From: Nolan, Chris <Chris.Nolan@lancashire.gov.uk>
Sent: 01 June 2017 07:59
To: Stephen Kilmartin; planning
Cc: LHS Customer Service
Subject: FW: D3.2017.0422 - Rear of 30 Beverley Drive Clitheroe

With regard to the above planning application I feel that based on the present information provided I would have to object to this application on highway grounds with regard to the following points.

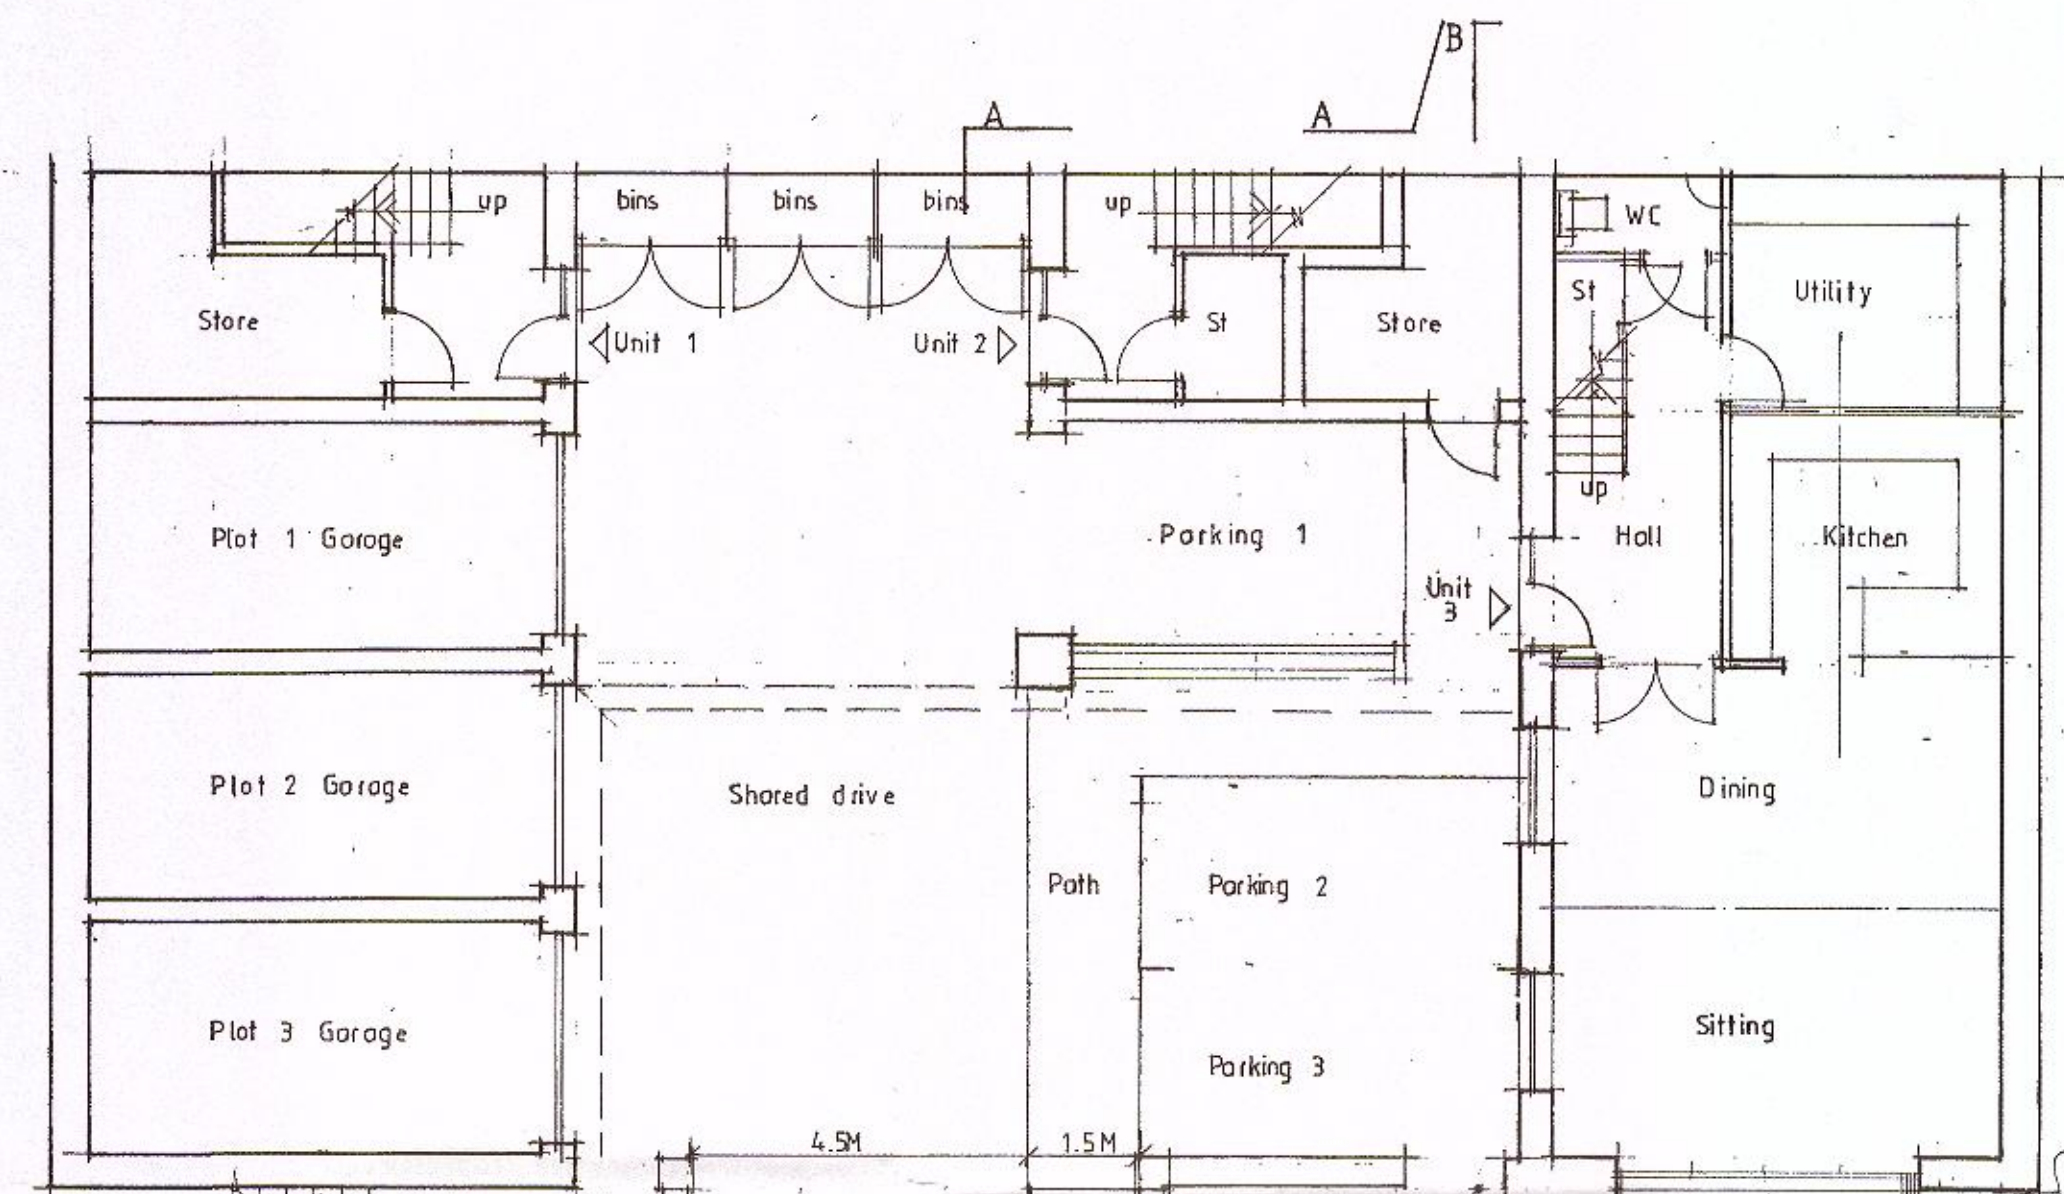
1. A new access point on Primrose Road would not be desirable. This is a narrow road that is a major access route to a high number of residential properties as well as an industrial development. At the position where new access point is proposed there is no adjacent footway so compromising safe pedestrian access.

2. The parking arrangements within the site need to be proven that they are all accessible independently in such a manner that all vehicles can enter and leave the site using forward gears. By independently I would want any vehicle to be able to complete the necessary manoeuvre whilst all other bays are in use.

3. The sight line for the access would need to be proven for the speed of the road. Initial investigations have indicated that some vehicles significantly exceed the 20 mph speed limit during the relatively busy daytime. As sightlines are set according to the speed of vehicles on the road rather than the established speed limit before I can agree that the drafted sight lines are sufficient, I would require a speed survey taken over 24 hours each day for a period of seven consecutive days, (This can be completed automatically using either ribbon or radar technology).

4. The retaining wall between the site and Primrose road is presently above 1.0m high. If it is found that the planned provision for the sight lines for vehicles exiting the site are adequate then the wall height would have to be reduced to 0.9m so that this does not conflict with the sight line requirements.
